**Consultation Response from KC,
Ecology Unit**

**2026/90706 Mars Care And Treats Petcare Europe Ltd, Oakwell Way, Birstall, Batley,
WF17 9LU**

Erection of temporary portakabin building for a period of 5 years

Responding Ref: 2606/07

Ornamental hedgerow to the northeast of the Site

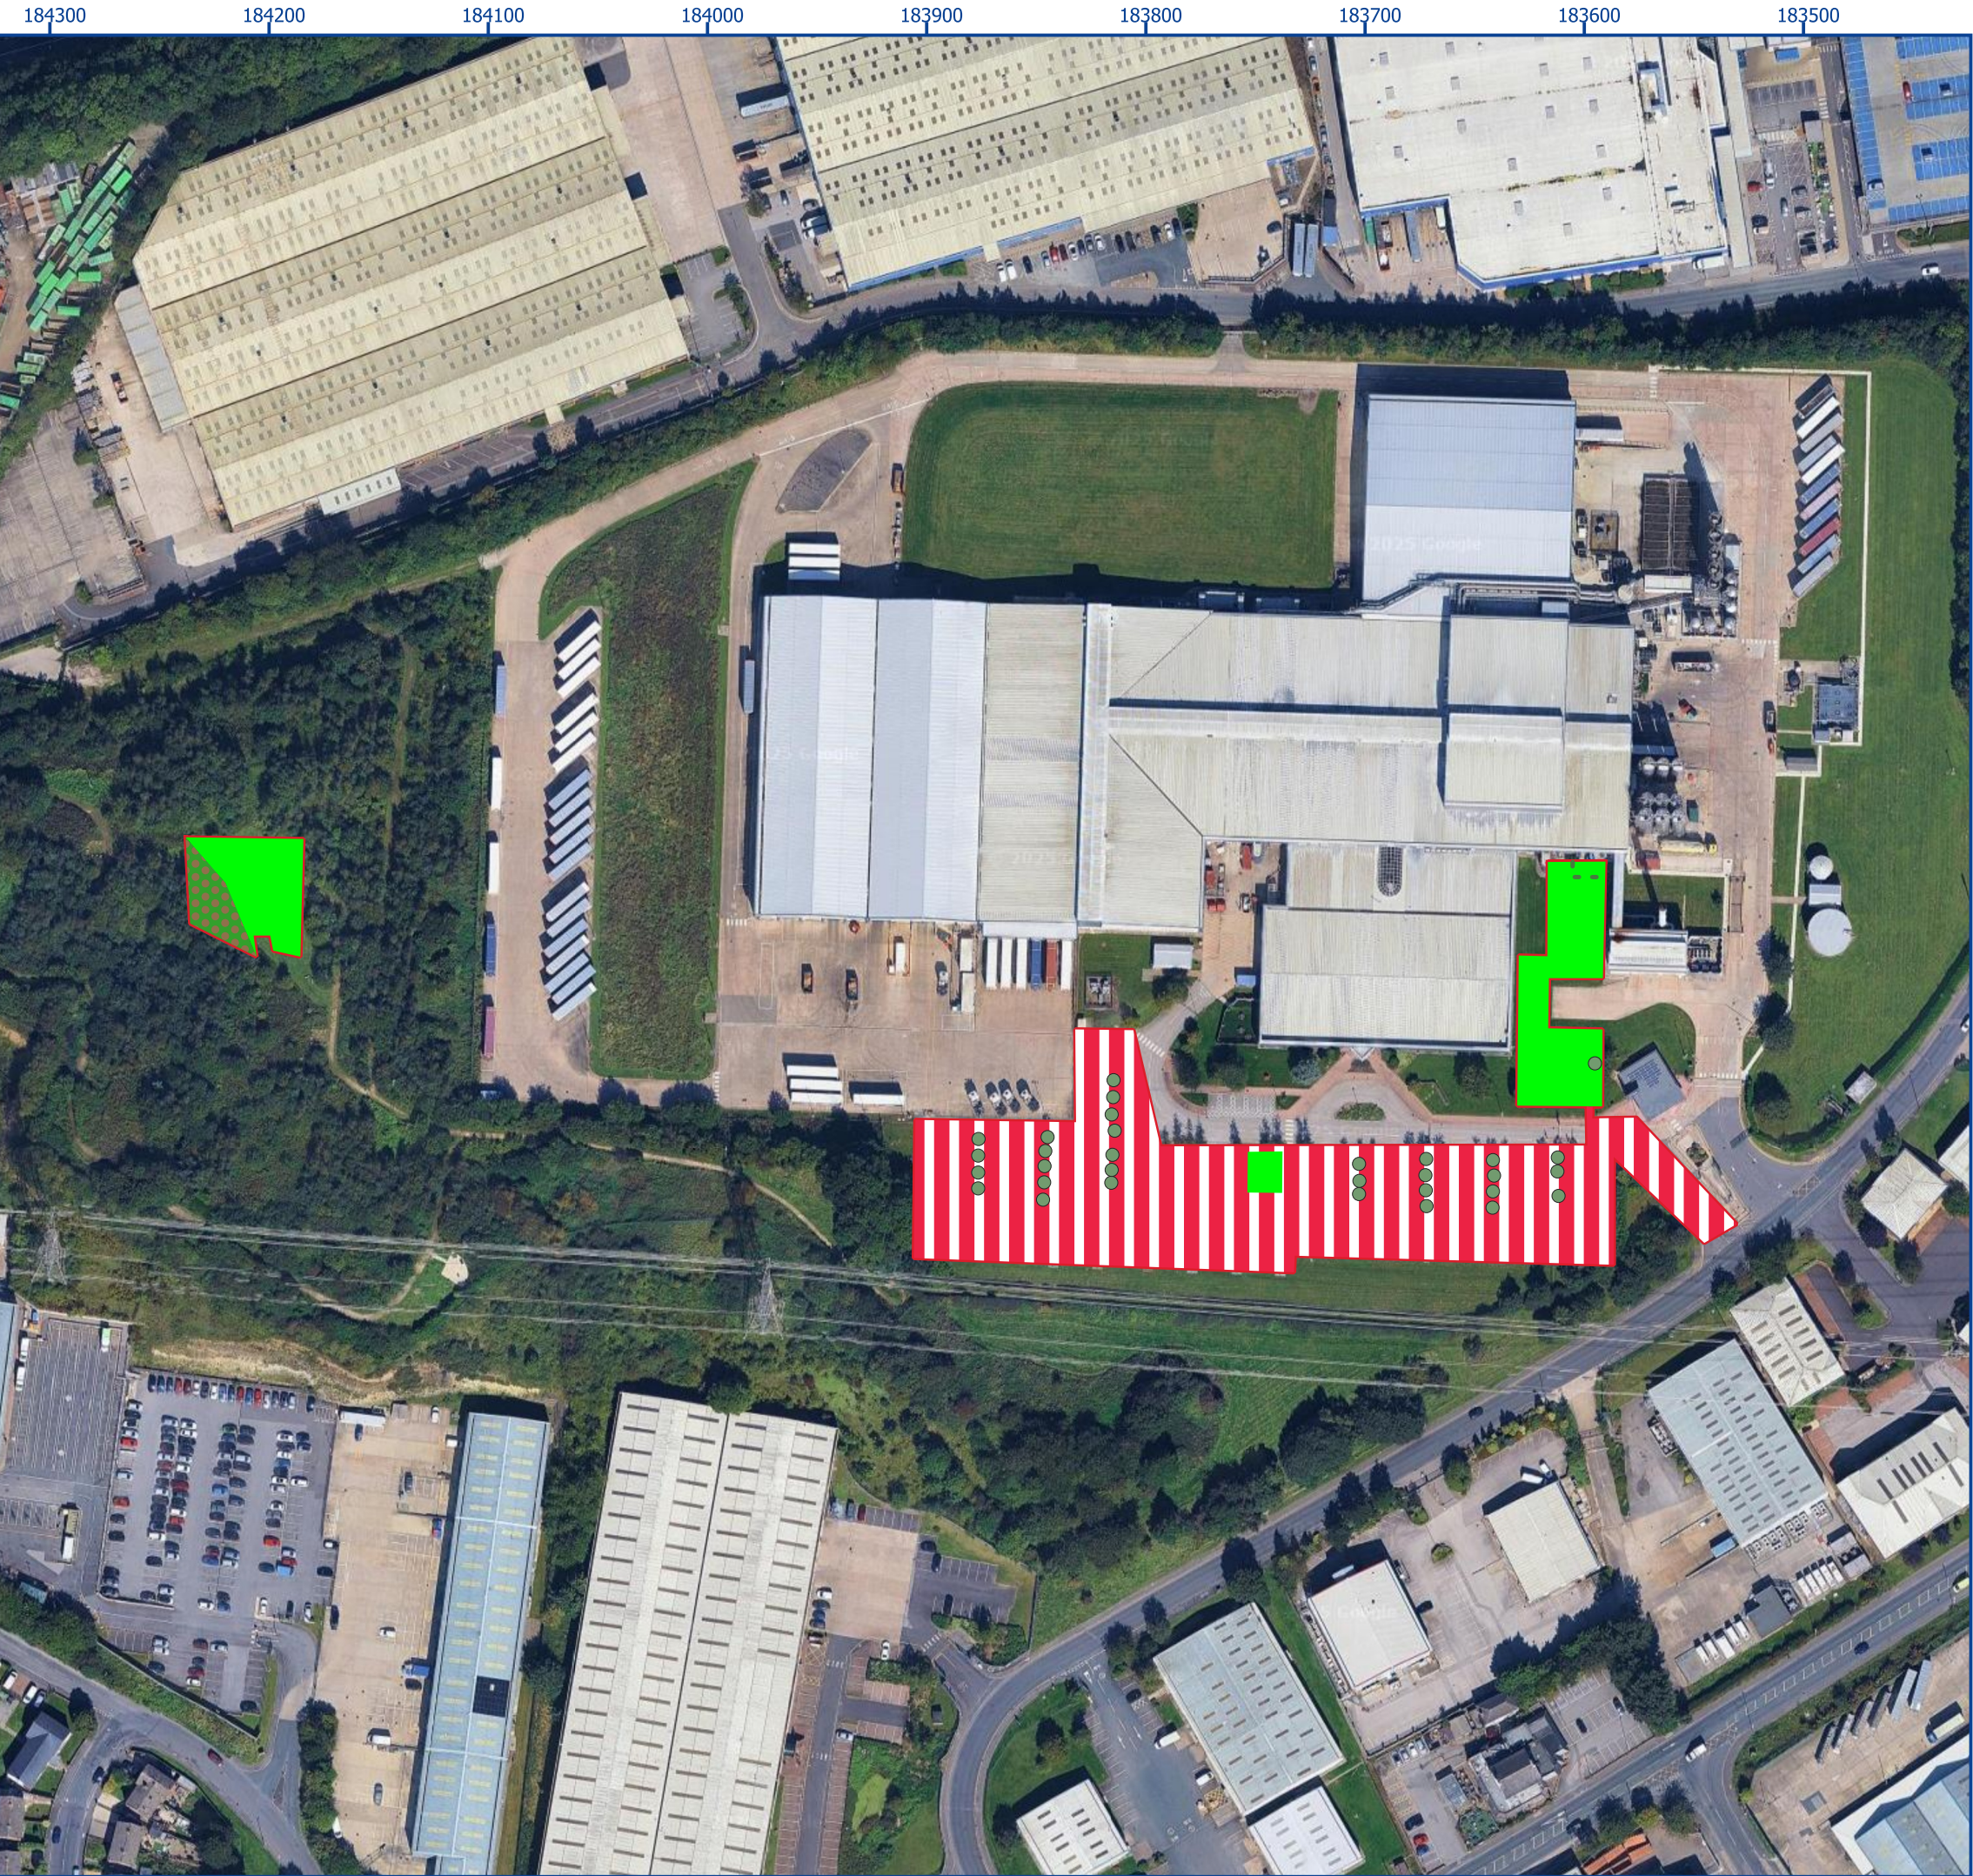
As included in the Kirklees Ecology comments (April 2026), given the existing habitats in the location proposed for the modular unit, and the industrial surrounding land use, it is unlikely that protected or priority species are present and likely to be affected by the proposals. However, as there is an existing hedgerow to be removed, I would recommend that a breeding bird condition is included in any consent.

Breeding birds

No removal of vegetation that may be used by breeding birds shall take place between 1st March and 31st August inclusive, unless a competent ecologist has undertaken a careful, detailed check for active birds' nests immediately prior to the works and provided written confirmation that no birds will be harmed and/or that there are appropriate measures in place to protect nesting bird interest on site. Any such written confirmation should be submitted to the local planning authority.

Landscape Proposals

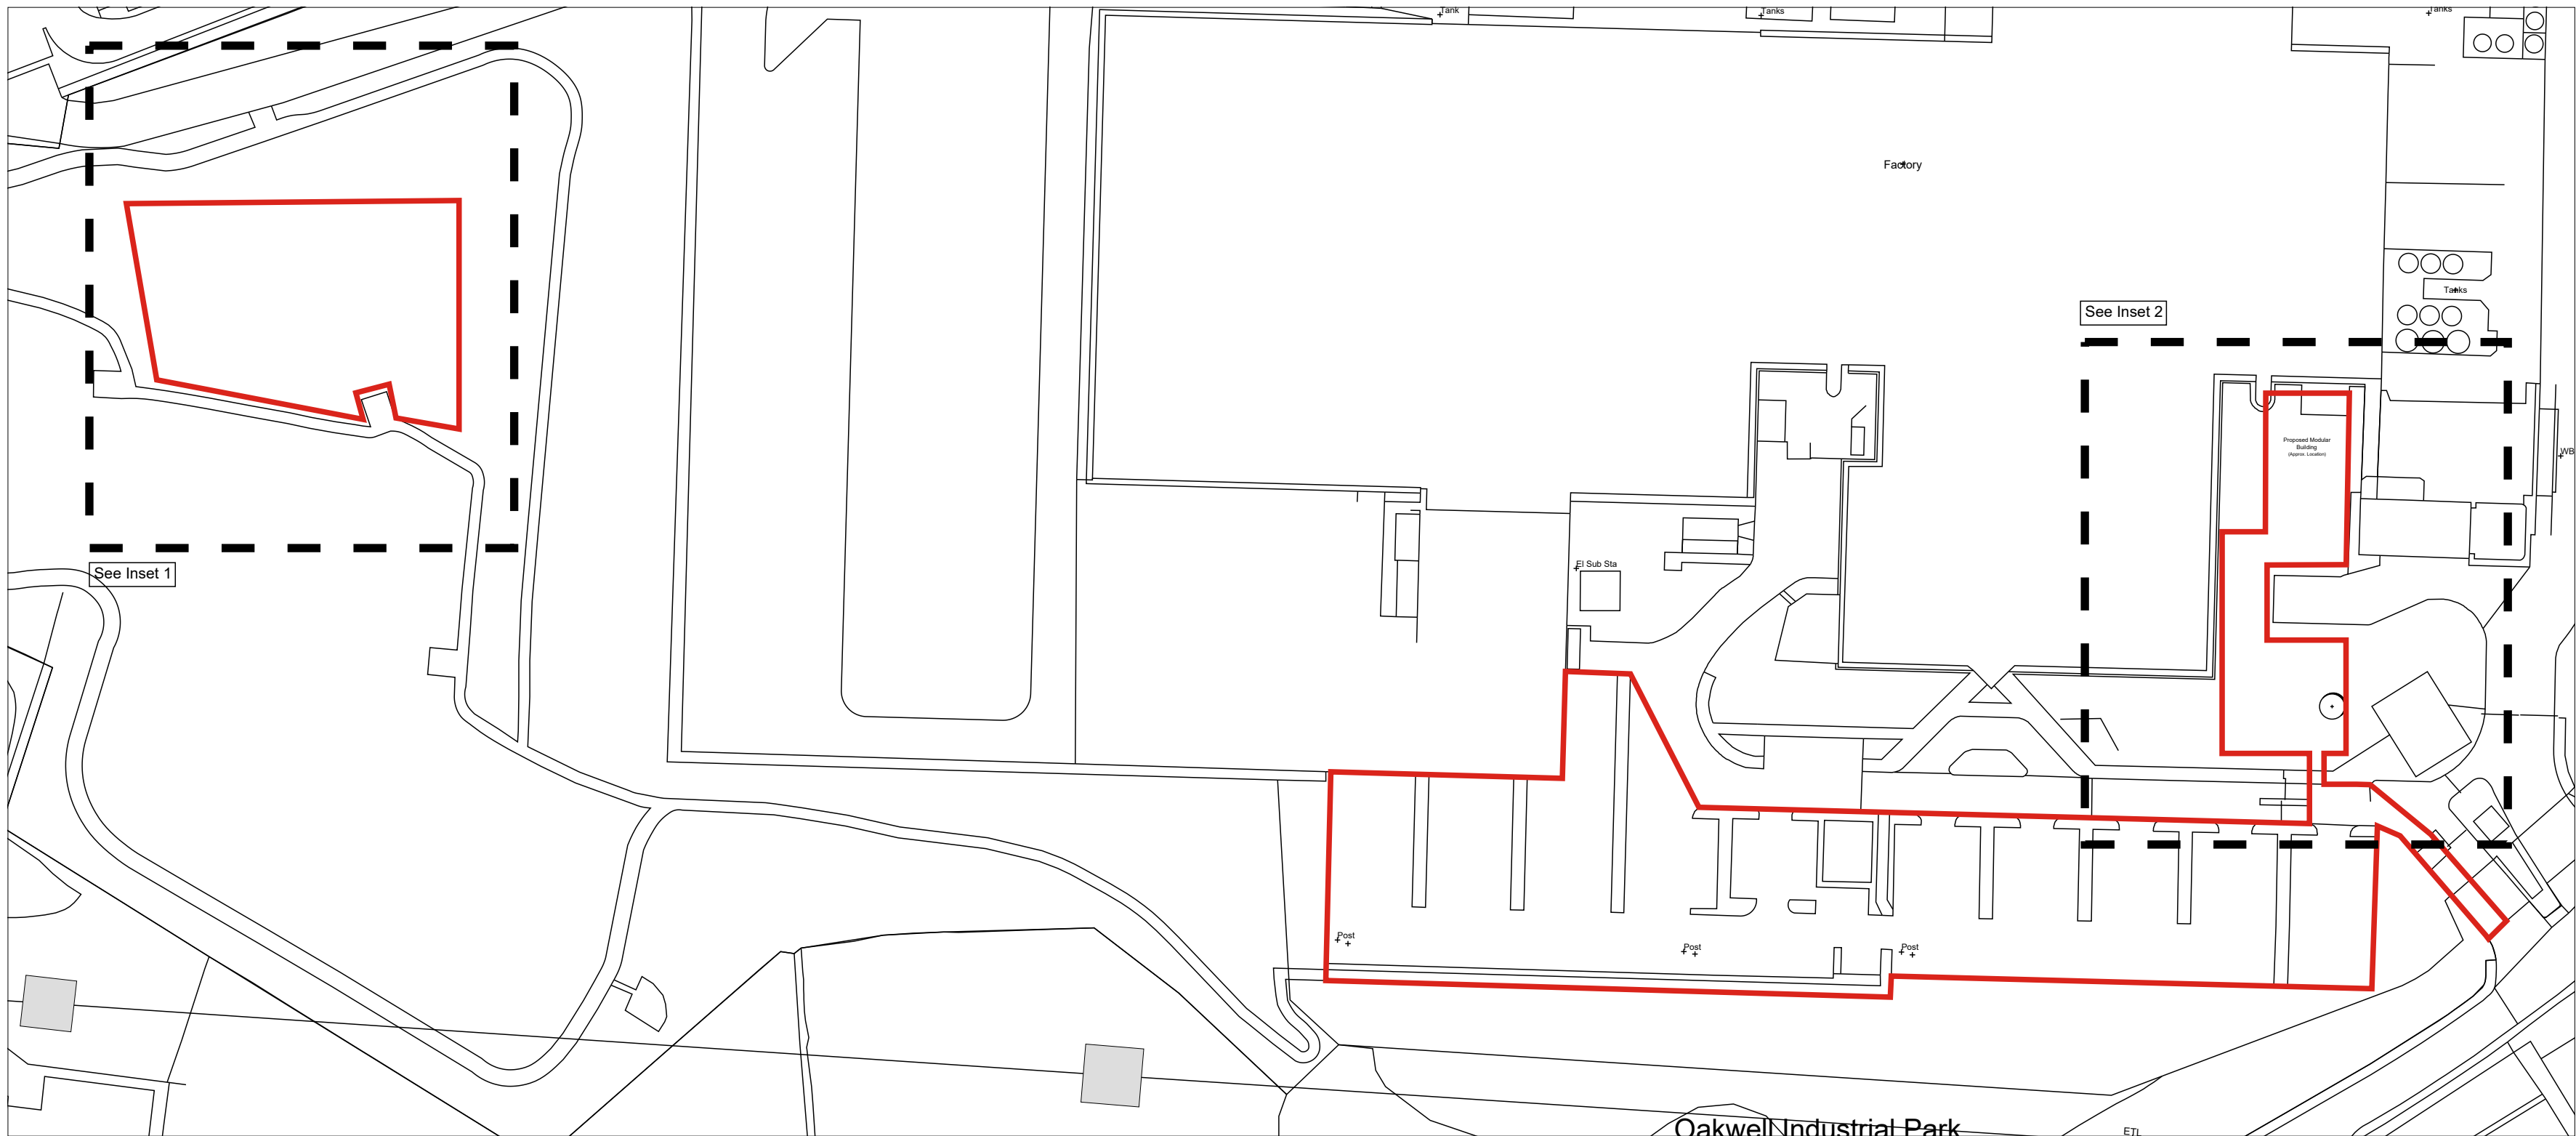
I have reviewed the revised information submitted and I am satisfied with the information submitted. The Biodiversity Net Gain Metric demonstrates that an area of Modified Grassland will be lost to the modular unit, and an area of Modified Grassland will be enhanced to Other Neutral Grassland in Moderate condition. The Biodiversity Net Gain informative should be included in the decision notice for this application.

Biodiversity Net Gain Informative
